# CITY OF ALBUQUE

October 26, 2021

**Re: Congress Apartments**  
**9441 Eagle Ranch Rd. NW**  
**Traffic Circulation Layout**  
Architect's Stamp 09-28-21 (C13-D033)

Based upon the information provided in your submittal received 10-25-21, the above referenced plan cannot be approved for Building Permit until the following comments are addressed:

REVISION	DATE
RBA ARCHITECTURE, PC ARCHITECTURE PLANNING DESIGN 1000 1st Ave. NW Albuquerque, NM 87102 www.rbaarch.com	
DATE	09-28-2021
SHEET NUMBER	AS-1.0

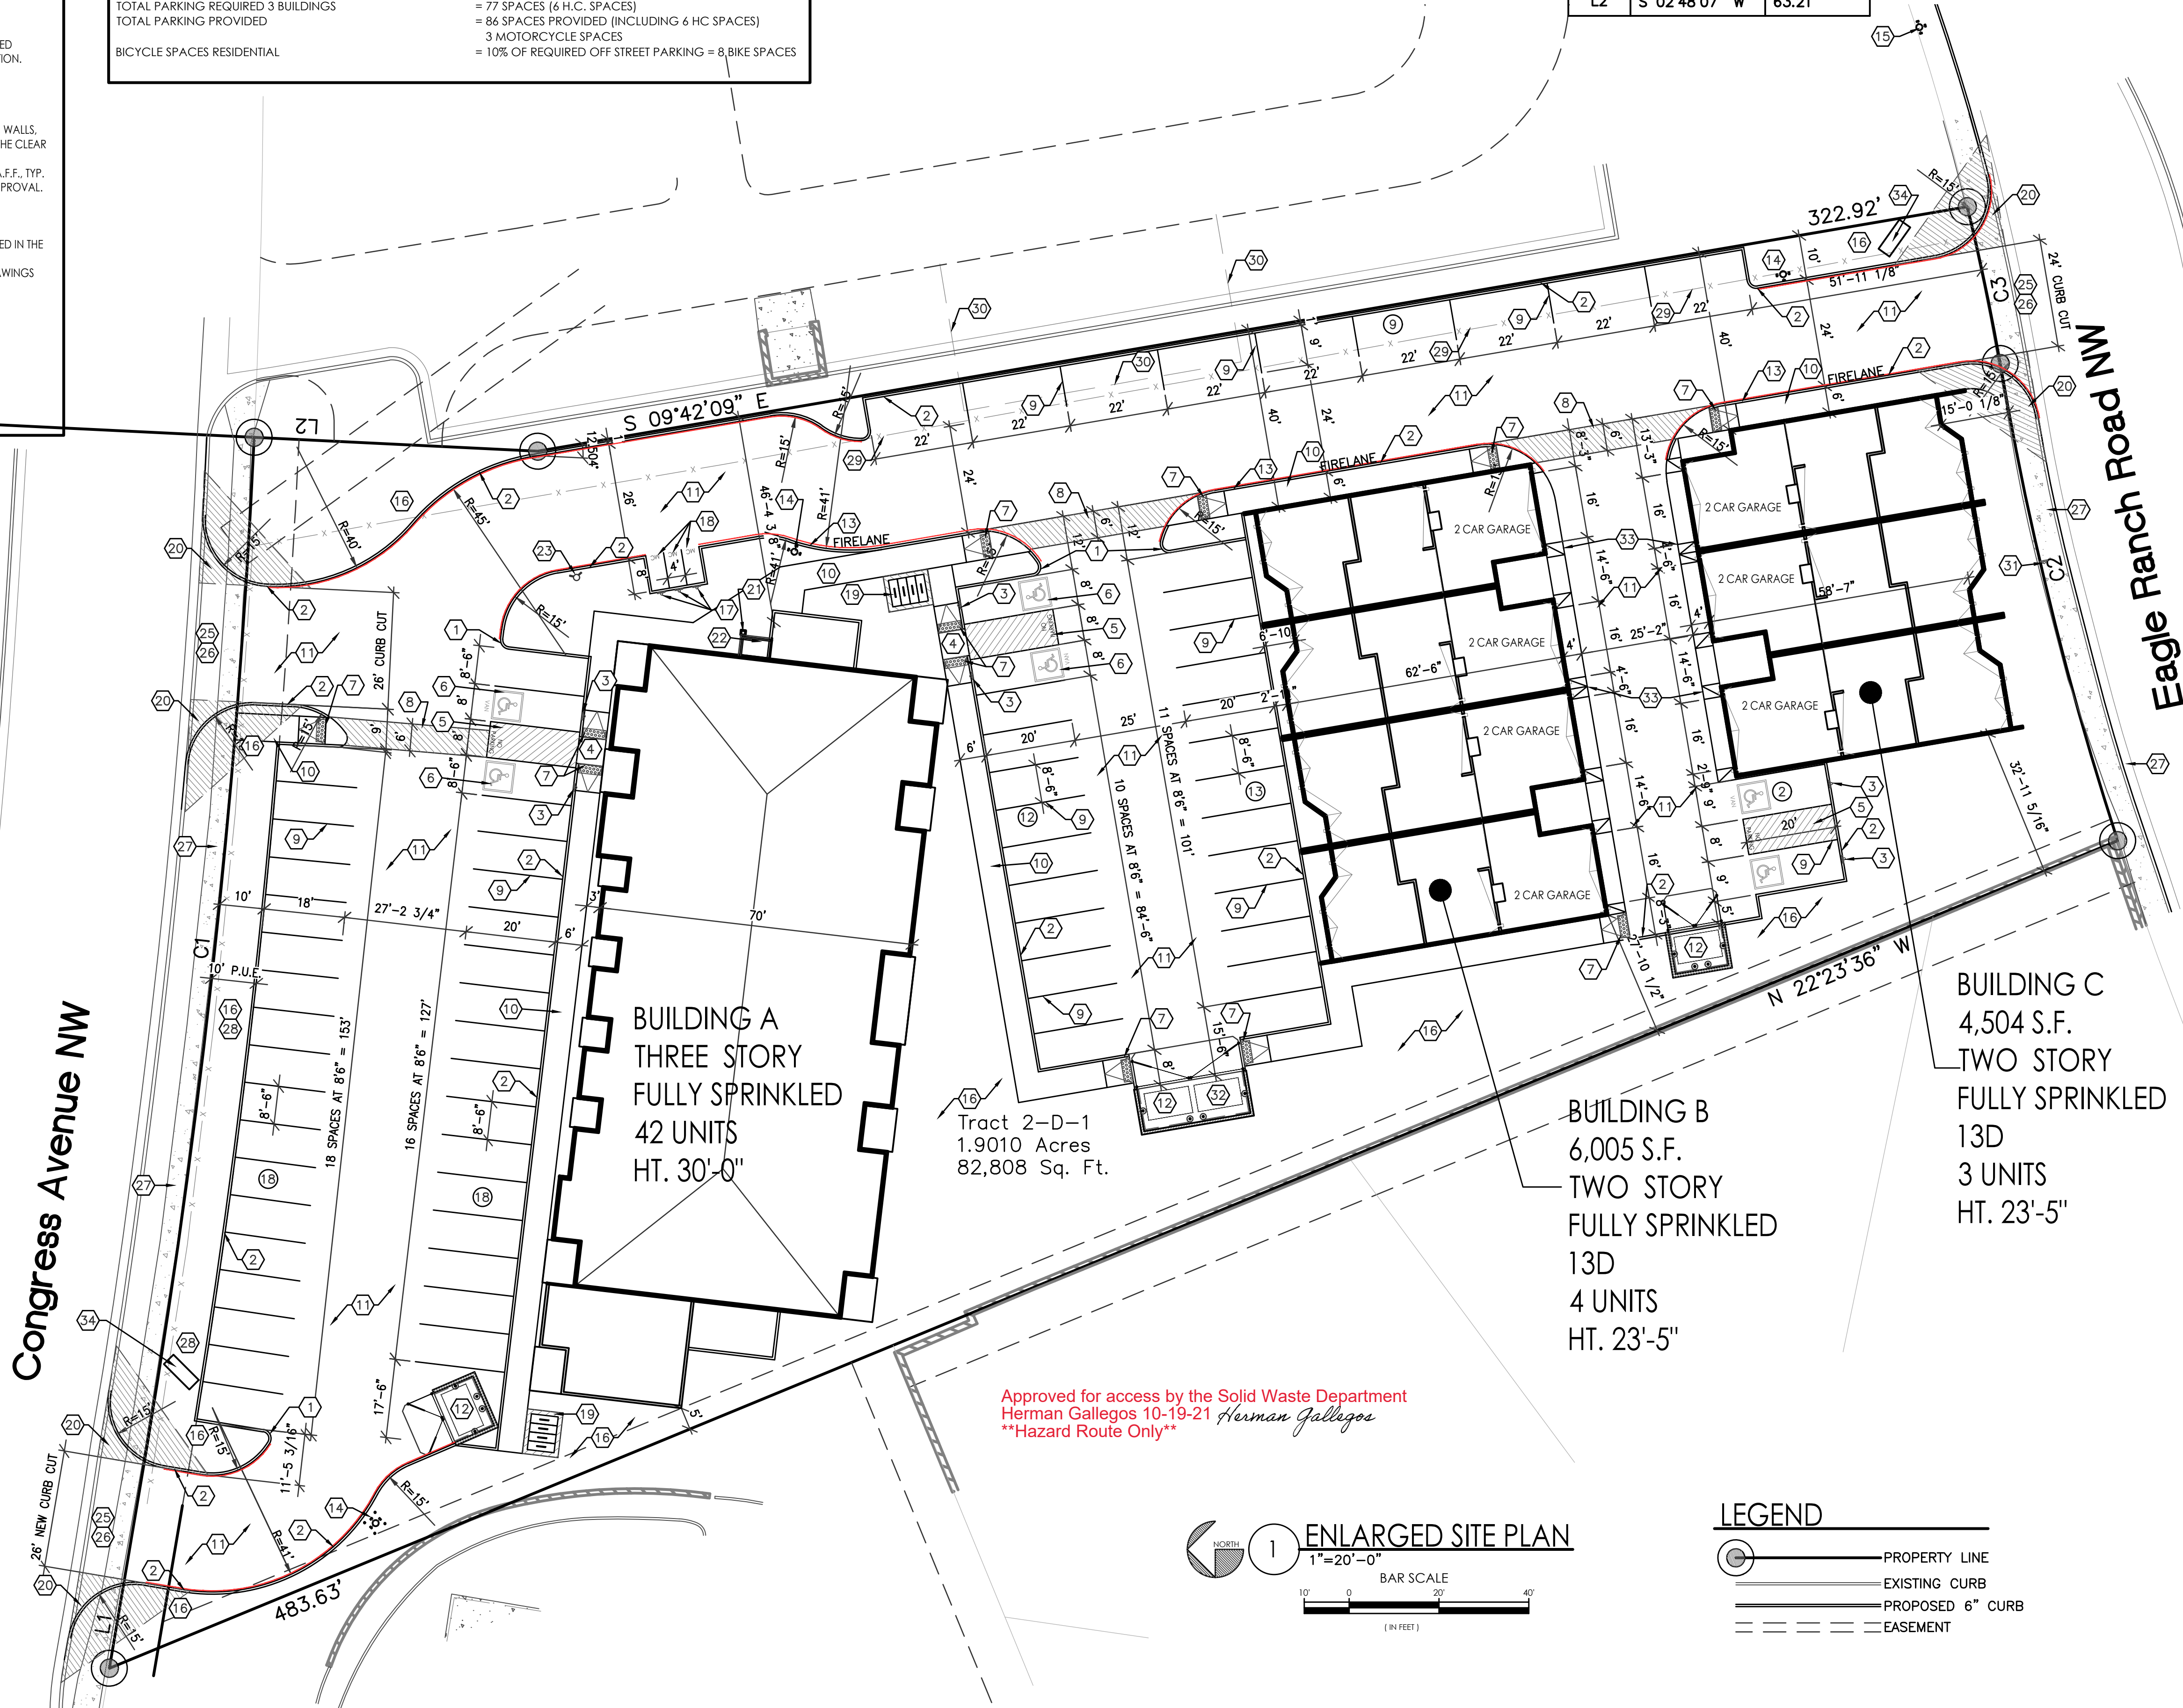
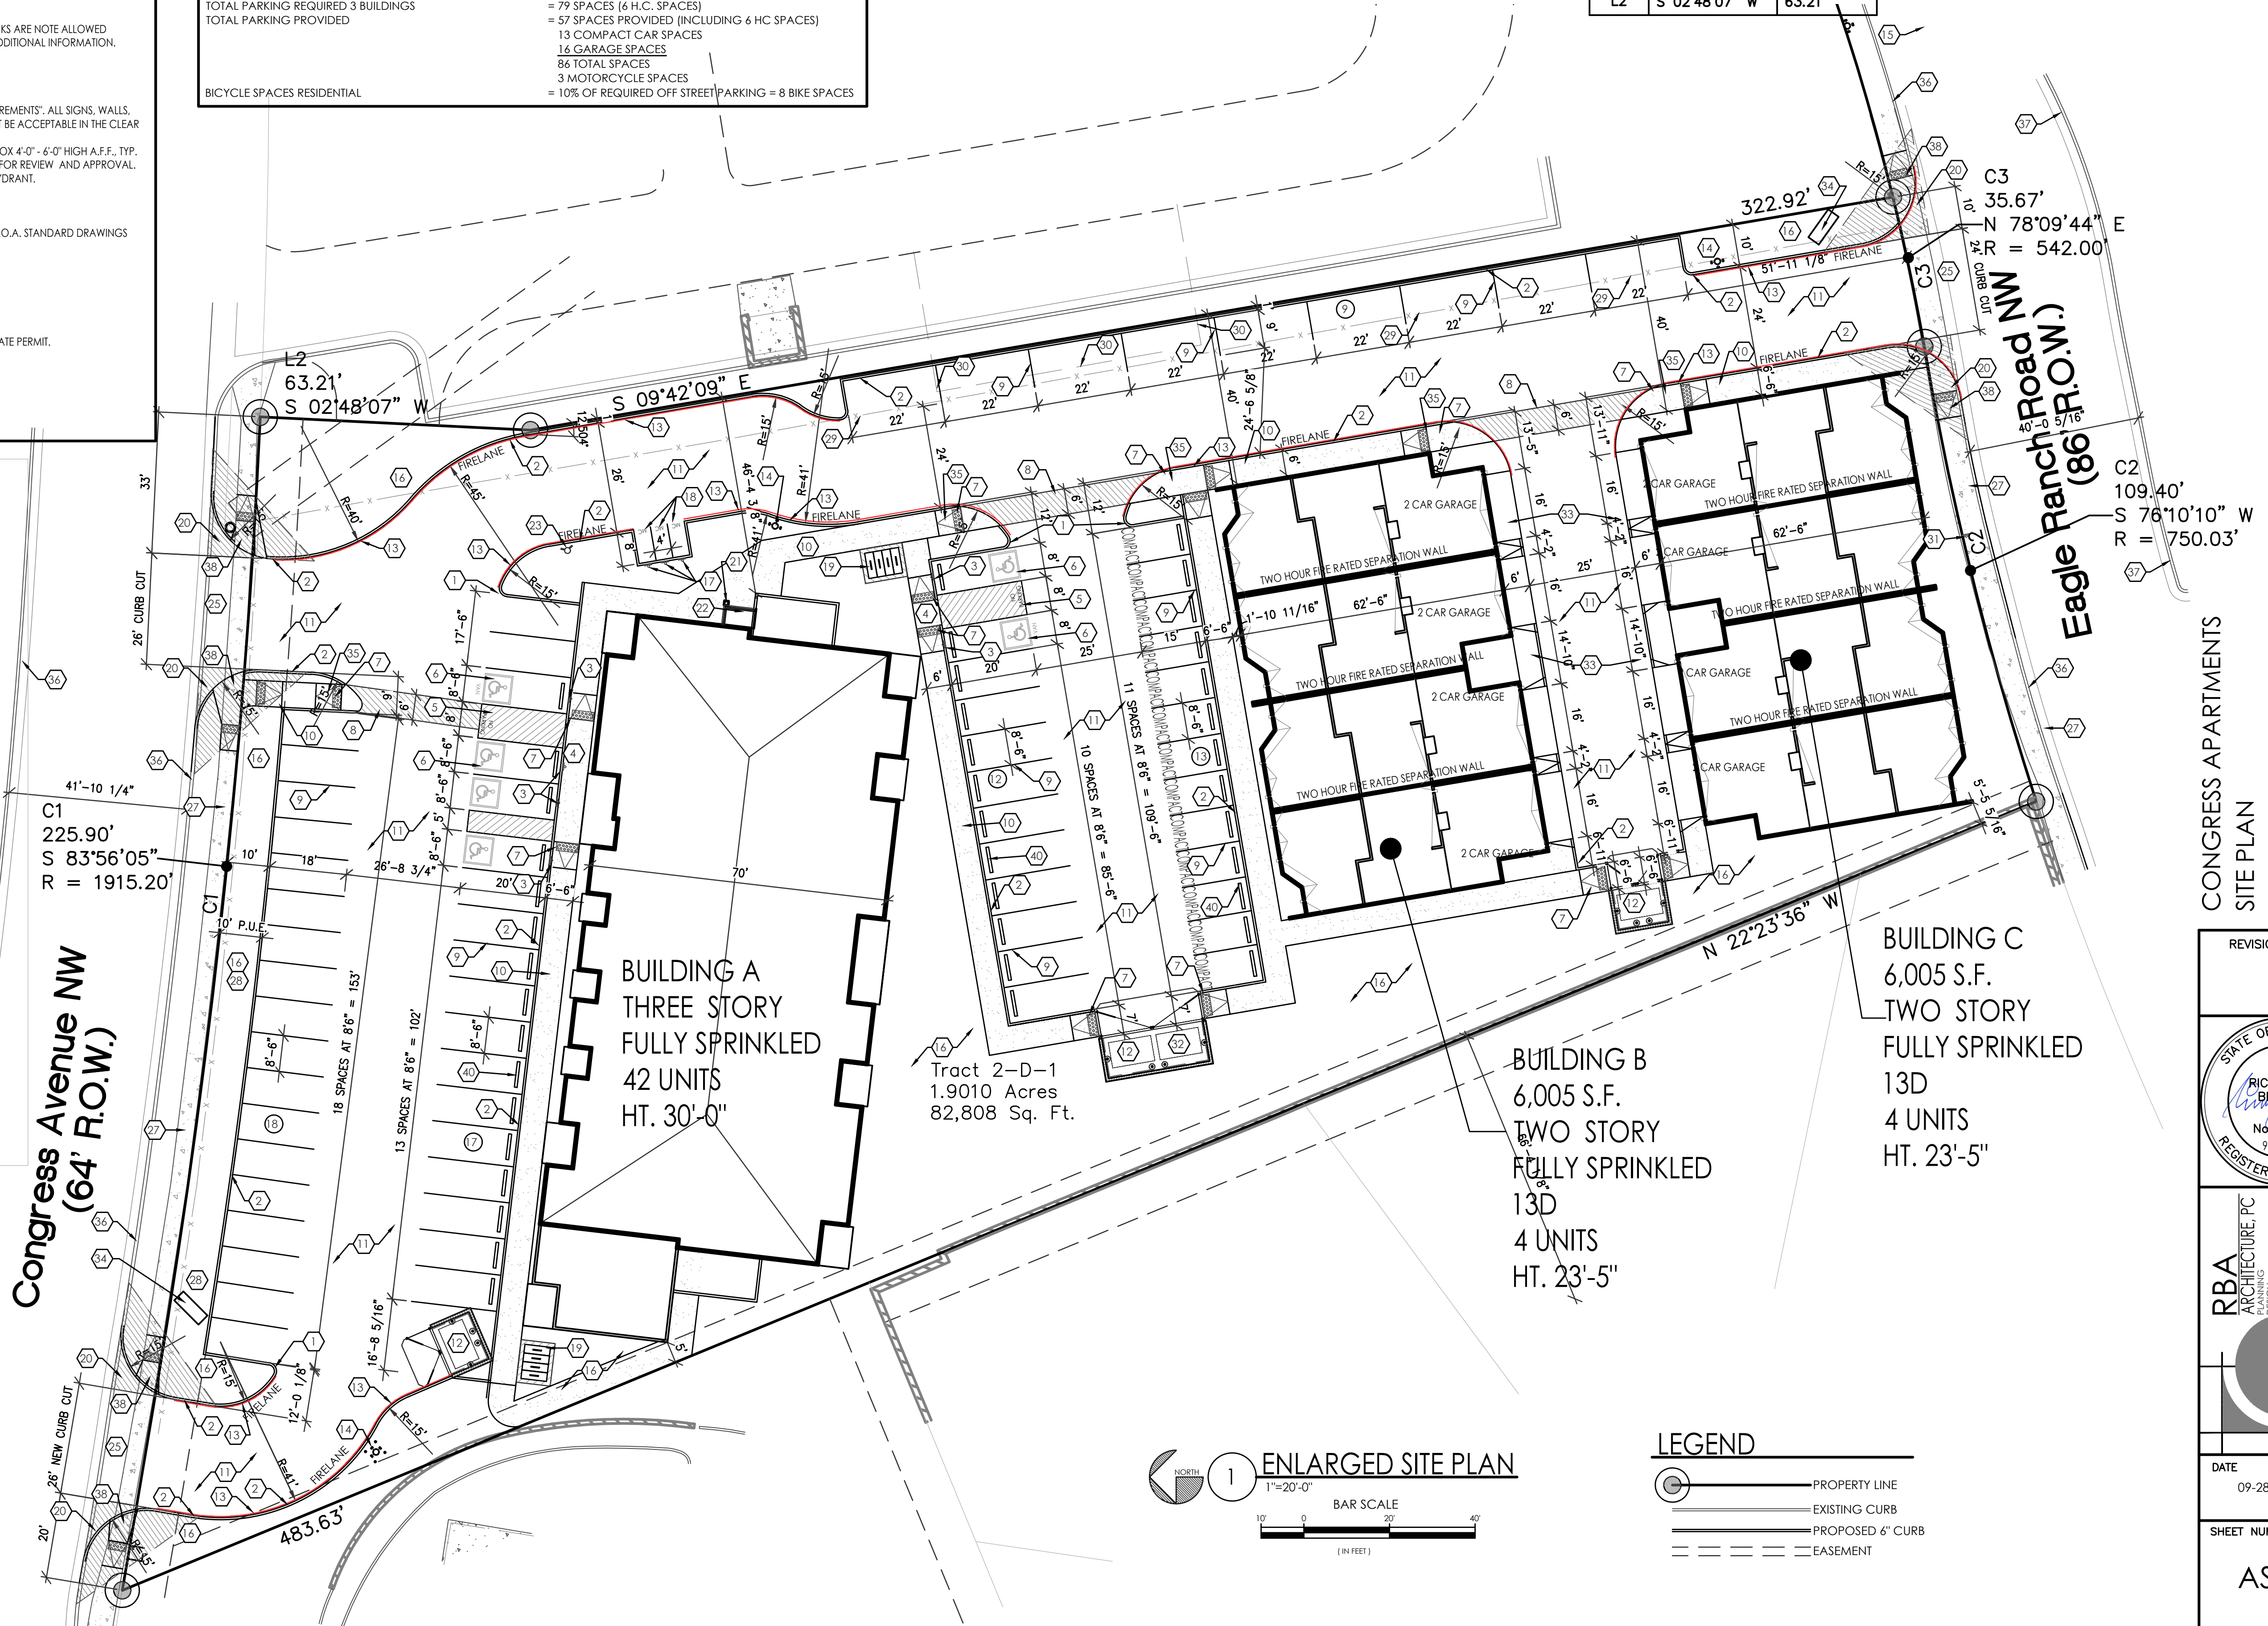
1. Identify the right of way width, medians, curb cuts, and street widths on Eagle Ranch rd. and on Congress Ave.
2. Per DPM, a 6 ft. wide ADA accessible pedestrian pathway is required from the ADA parking stall access aisles to the building entrances. Please clearly show this pathway and provide details.

3. ADA accessible pedestrian pathway should not be placed behind parking space or adjacent to a vehicular way. Vehicle and pedestrian/wheel chair conflicts should be avoided as much as possible.

4. Key note 4: proposed accessible curb ramp is not per COA standard DWG. Remove details A10 AS-2.0.
5. Key note 6: handicap symbol per ADA standards.
6. Key note 8: are you propose cross hatching? If so please provide details.

7. Key note 10: take out COA standard refrence on key note 10.
8. Key note 13: all fire lanes need to be labeled. Follow fire 1 approved plan.
9. Key note 17: provide sign face details.

10. Key note 25: construct new driveway entrance per COA standards DWG. 2426.
11. Key note 26: Why you need a work order? Do you mean work order for Water Authority, (water and sewer/tubs)? explain

12. Key note 30: why you are working outside of the designated private property work limit?
13. Key note 33: why you are proposed key note 33, and why the curb stripe will be red?

14. Key note 34: add note for proposed Monument Sign to be located inside private property which includes Air Space.
15. Show proposed ramp symbol within COA ROW on each entrance .

16. It appears there will be a conflict area between proposed sidewalk and proposed ramp on both entrance. Please provide details.
17. Provide frontage dimensions of your site (segment length), at the Northside and at southside of the site.

18. Provide the dimension from the property line to both driveway access.
19. All internal proposed ADA ramps need details.
20. Southeast driveway access: provide adjacent property approval. Your site plan shows there will be work outside of the property line.

21. Provide barrier curb on site plan for ADA stalls parking and for all parking stalls that will encroach into sidewalk.
22. Please extend the island ramp that located at the northeast driveway access, to match the adjacent parking stall length.

23. Paint all proposed Bollards with yellow.
24. A8/ AS-2.0:
  - Slopes: 1:12 Max. and 50:1 Max. landing reflect.
  - Proposed ADA parking stall width need to be 8.5' not 8'.

- Provide sidewalk width.
25. The minimum parking stall dimensions are:
